Application for a non-material amendment following a grant of planning permission. Town and Country Planning Act 1990

Proposed business park, hotel, public house/restaurant, conference and function centre, petrol filling station, restaurant/cafe with ancillary retail together with associated landscaping, access, highways, parking, drainage, utilities and services and infrastructure works

H16-0009-14

Changes to improve environmental performance consisting of installation of photovoltaic cells on the roof, solar shading to some windows and revised ventilation grilles.

drg title
BREWERS FAYRE ELEVATIONS

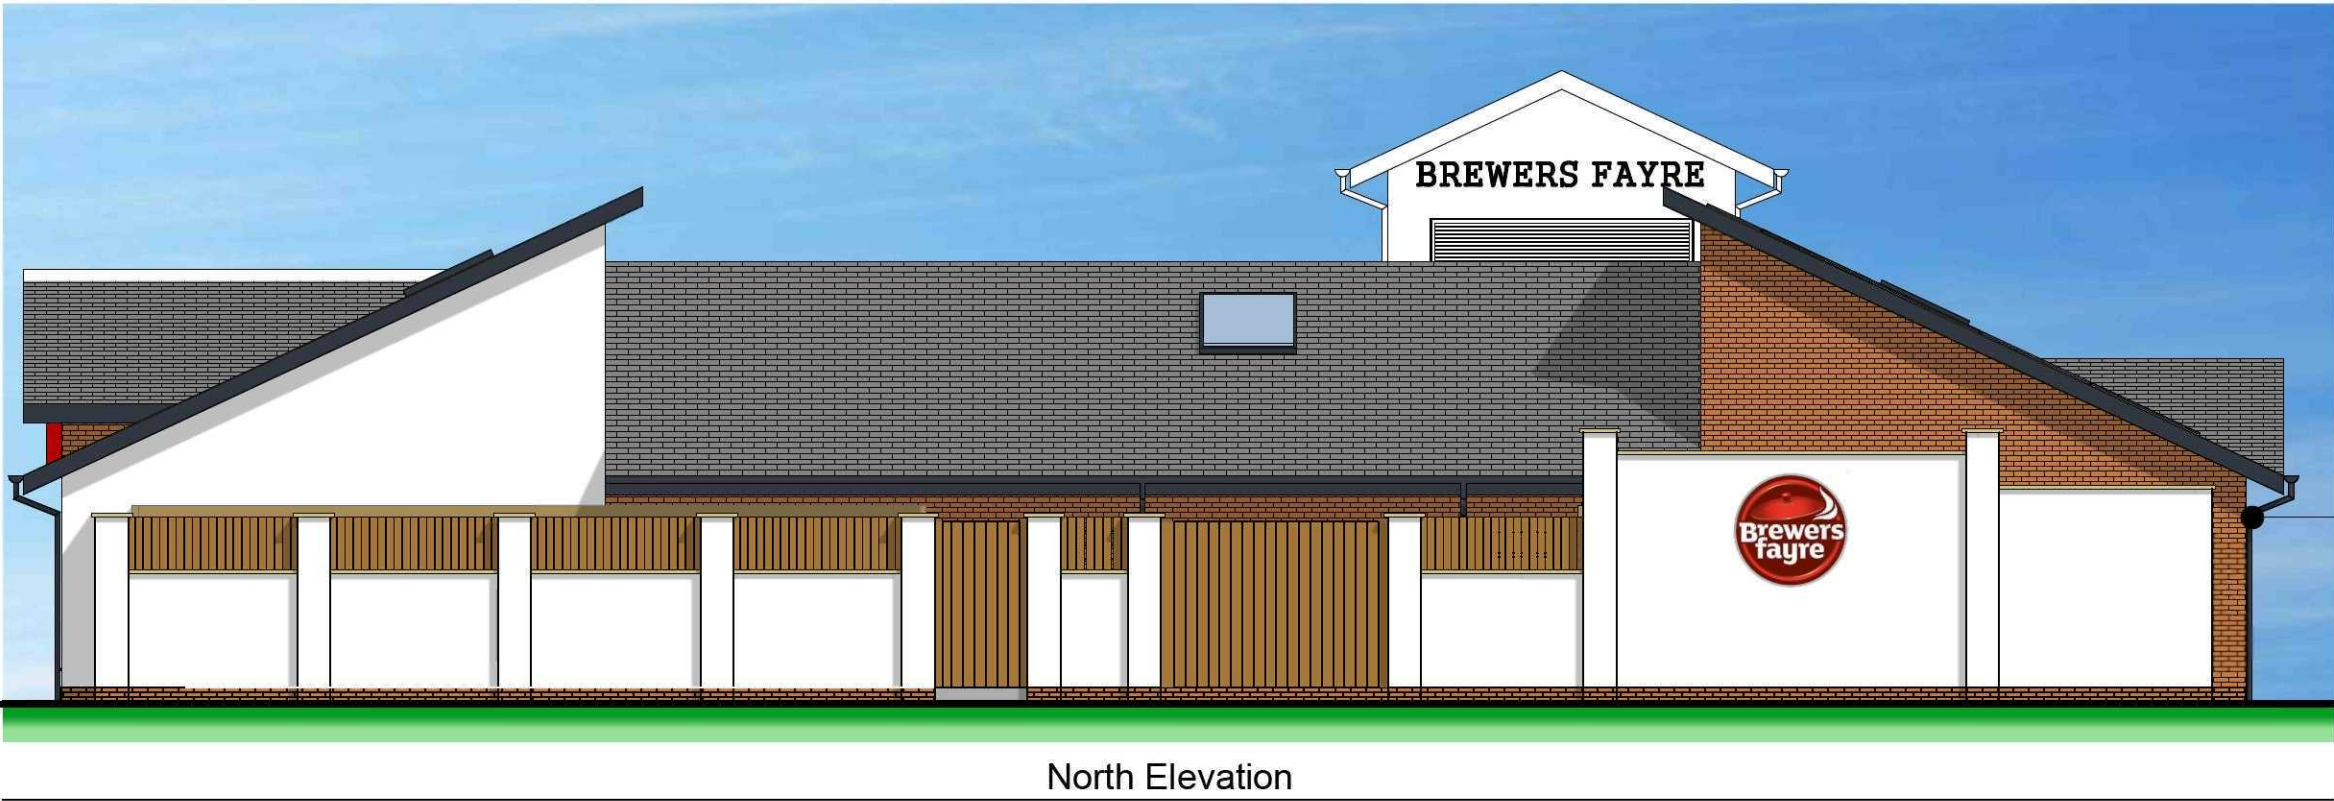
Parts of Brewers Fayre Elevations Dwg no. 1319/05B and Premier Inn Elevations Dwg no. 1319/06A
